# MAYBERRY COMMUNITIES

## SKETCH PLAN

EPC STORMWATER REVIEW COMMENTS  
IN ORANGE BOXES WITH BLACK TEXT

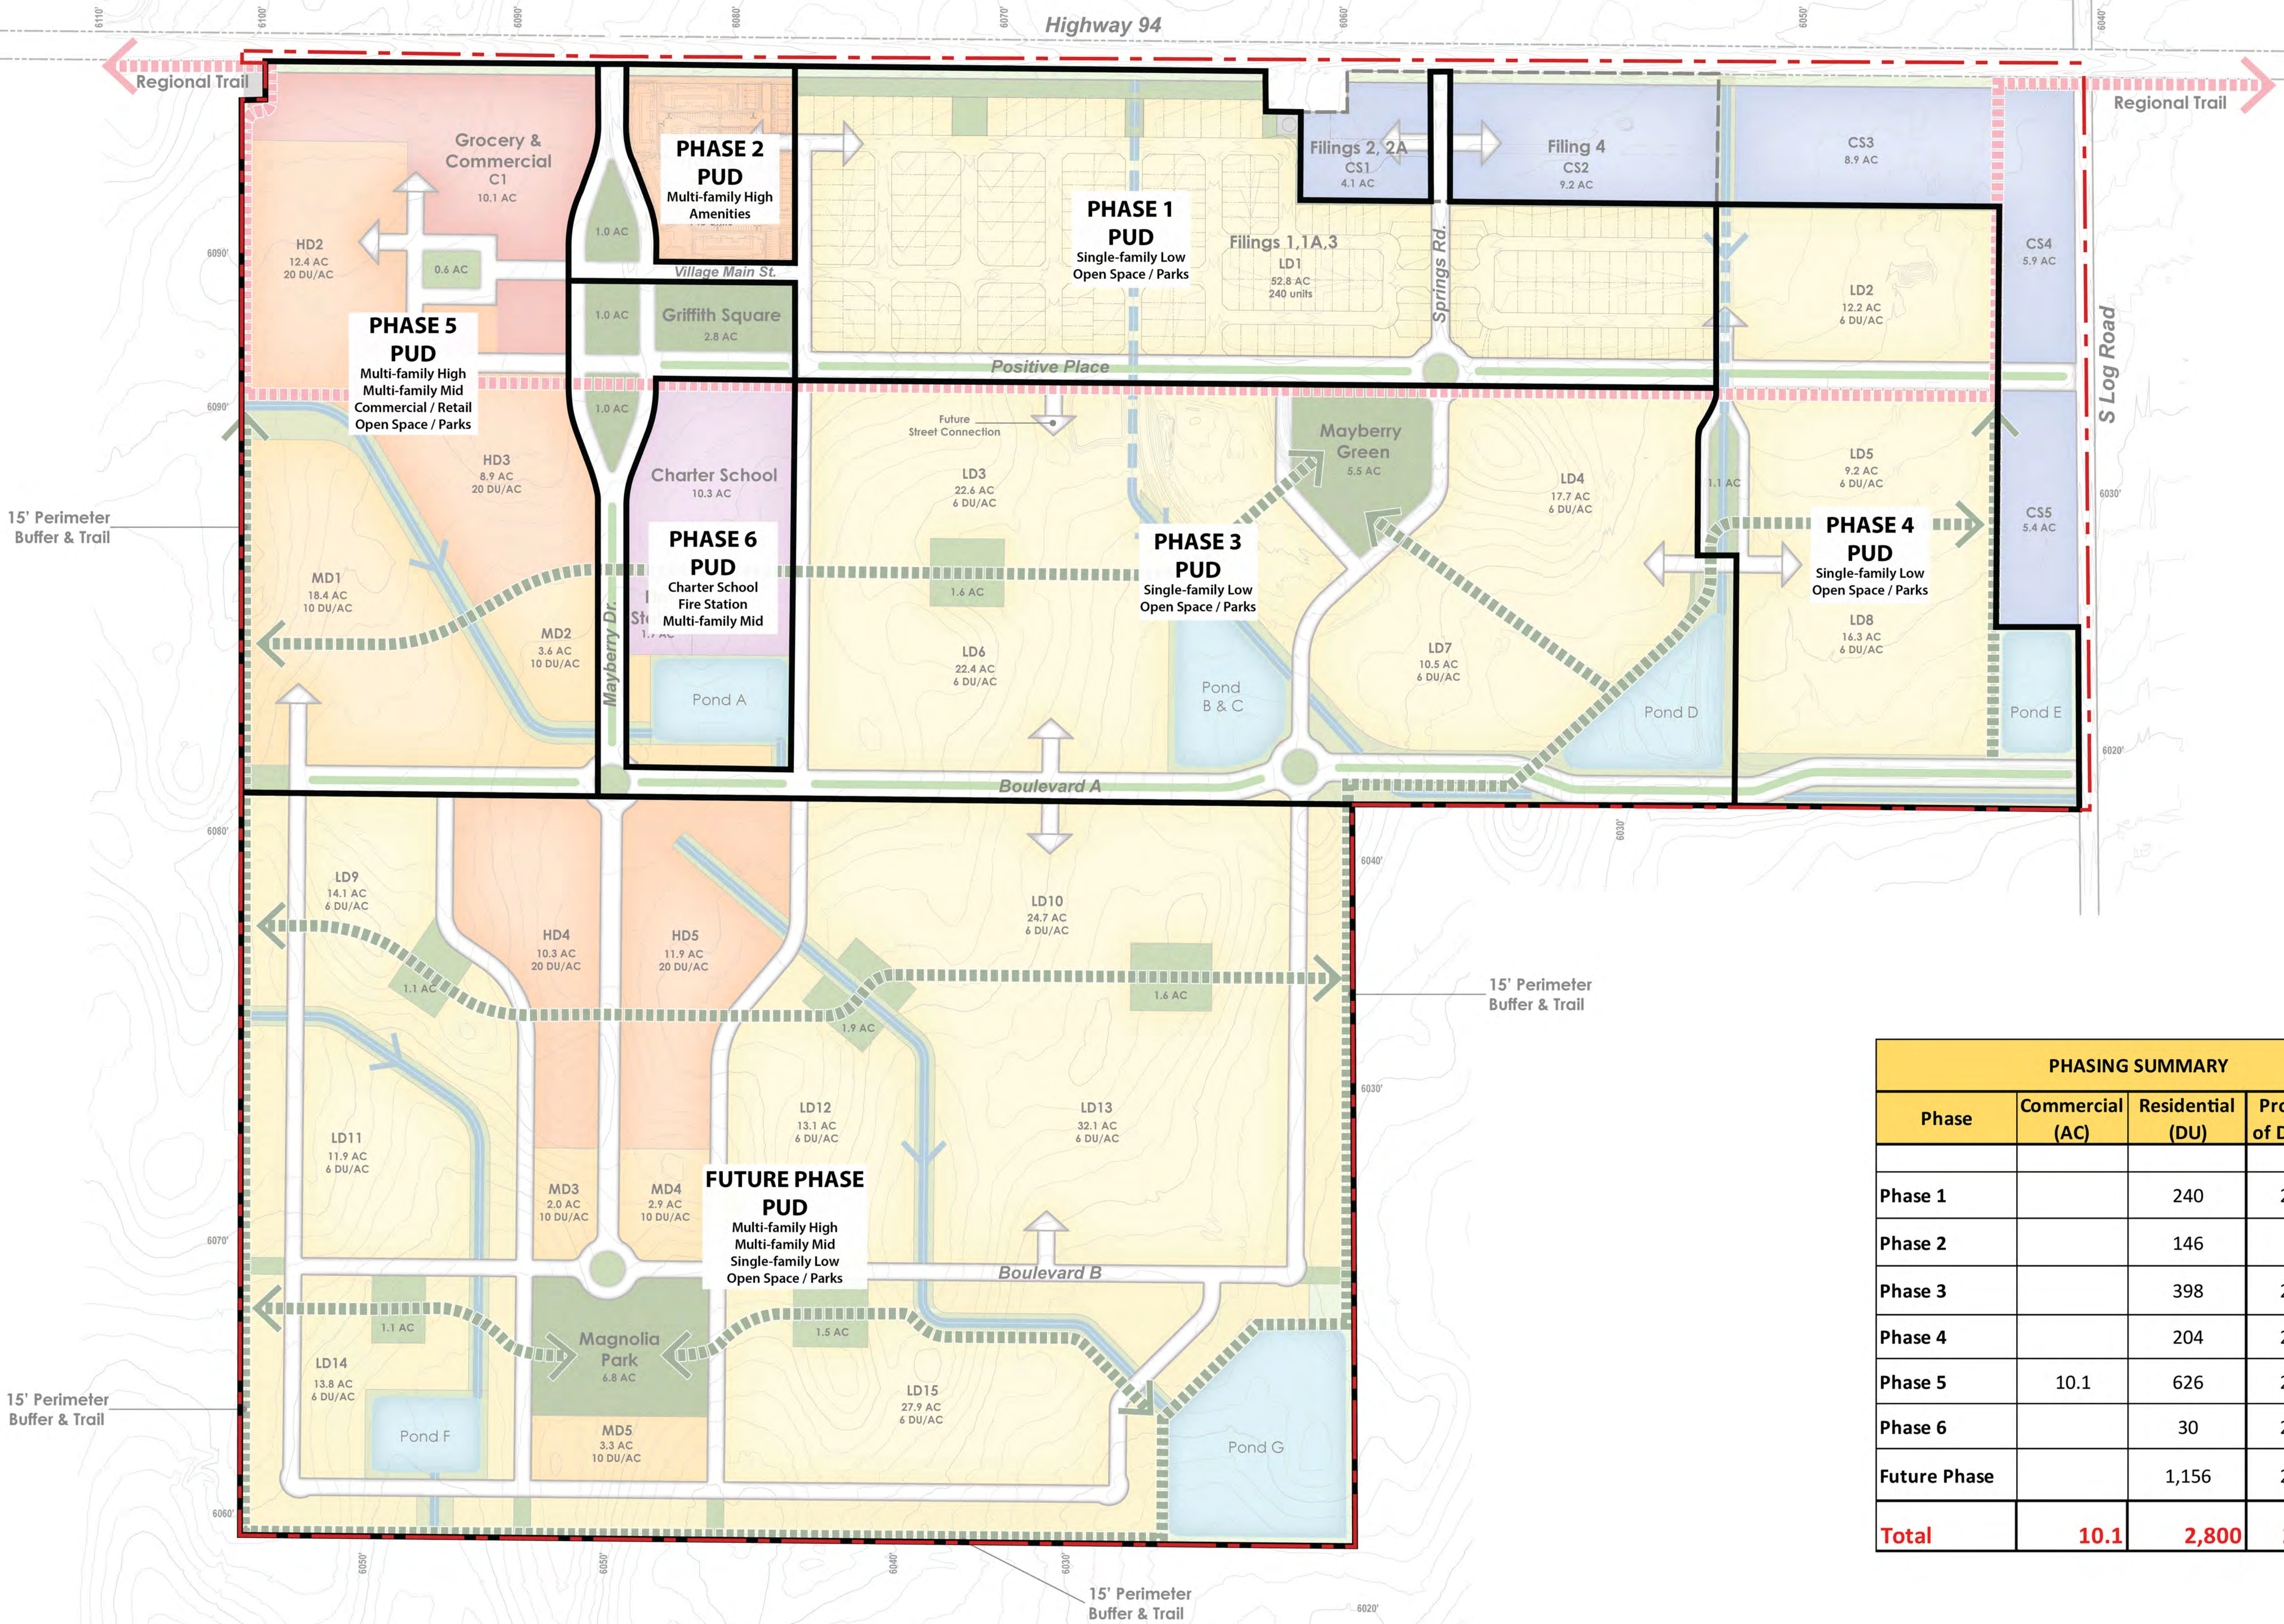
what phase are these commercial parcels in?

This should just be Pond B. Pond C is interim condition only

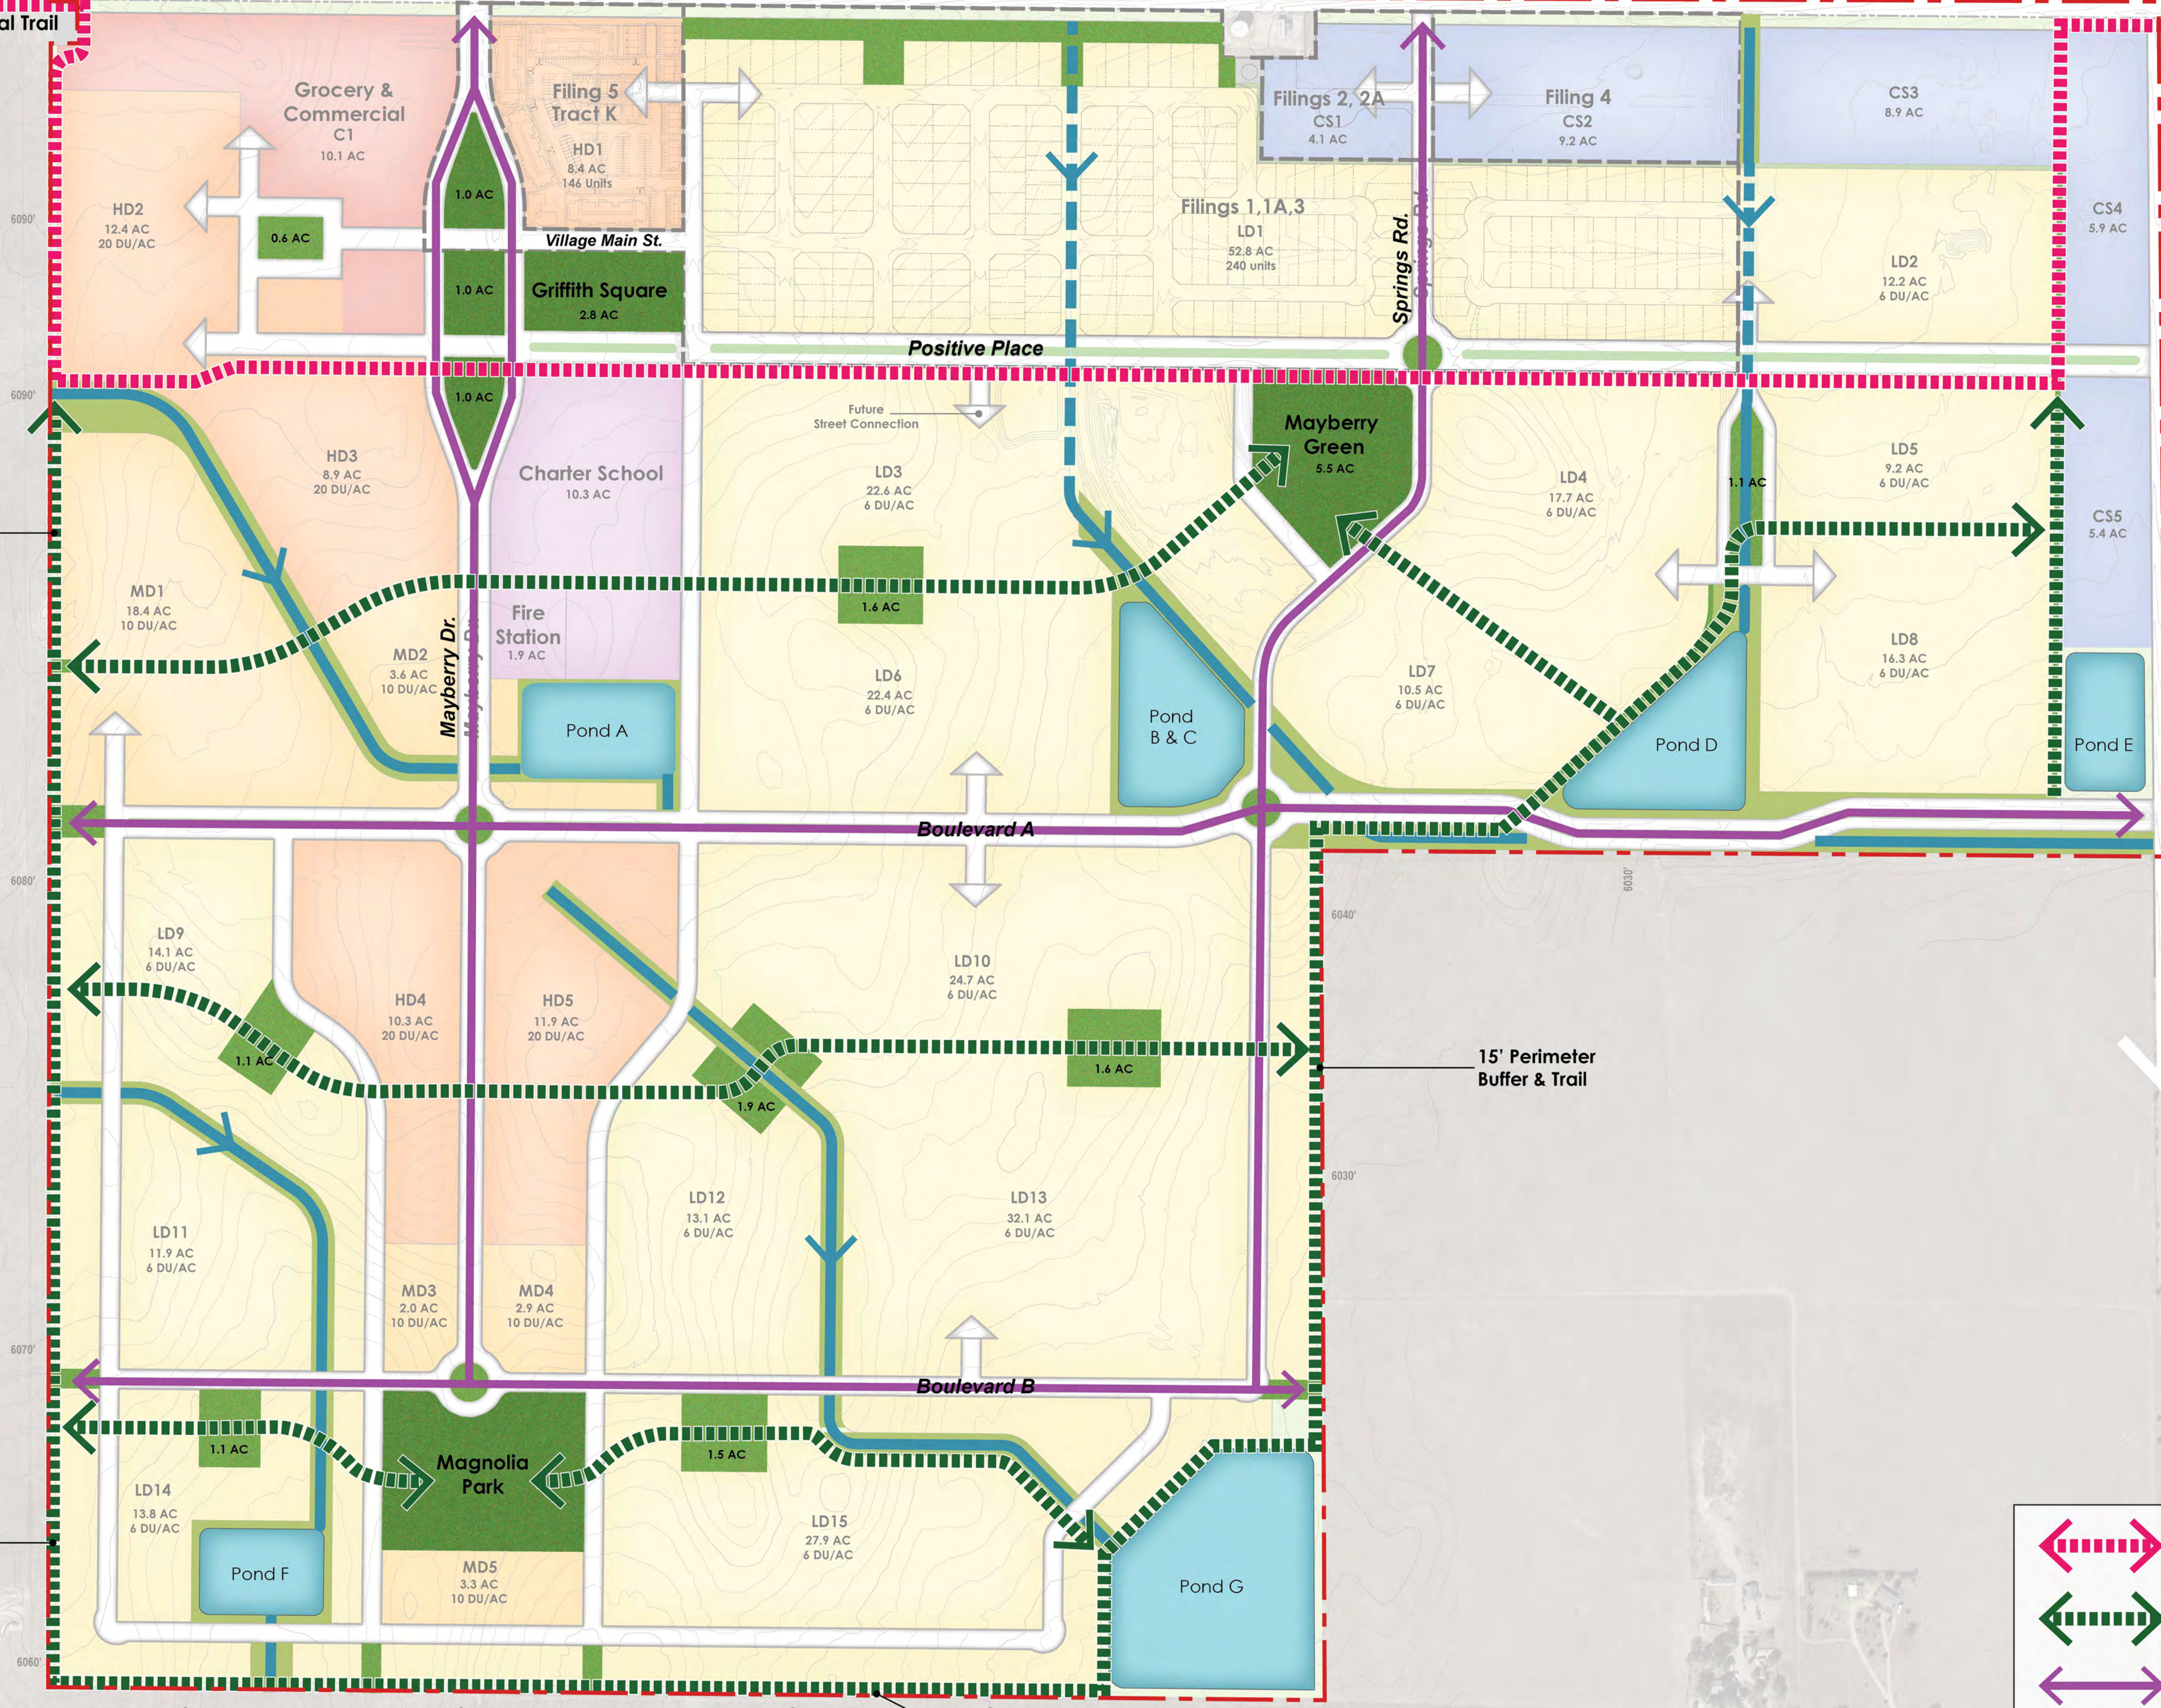
Why is Positive Place  
not a multimodal  
street. The road cross  
section identifies bike  
lanes, sidewalks, etc.

This page should identify which of the streets are  
proposed to be reserved for public right-of-way  
and which are proposed for private streets.
